FAO: Planning & Building Control
Application No. BR/129/21/OUT Site address 26 Burnham Road.
Application for 10 new dwellings

I feel that I must Strongly object to the granting of this applications on a number of current issues.

STREETSCAPE - SOUTH ELEVATION (PROPOSED) 1:100

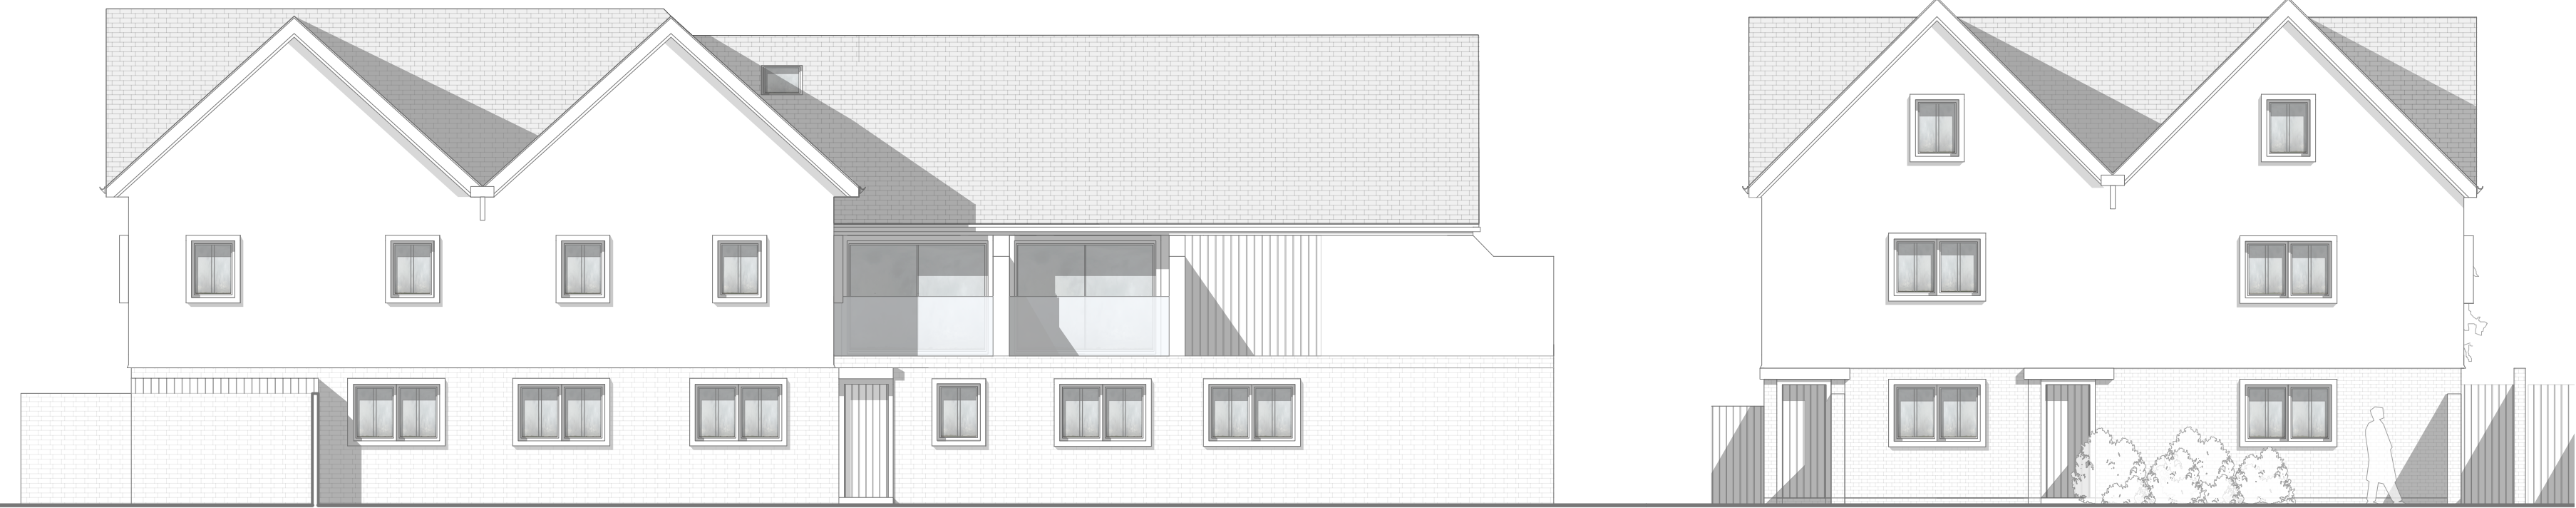
This application is far too dense and out of character for Burnham Avenue, in particular to the proposed three storey building!
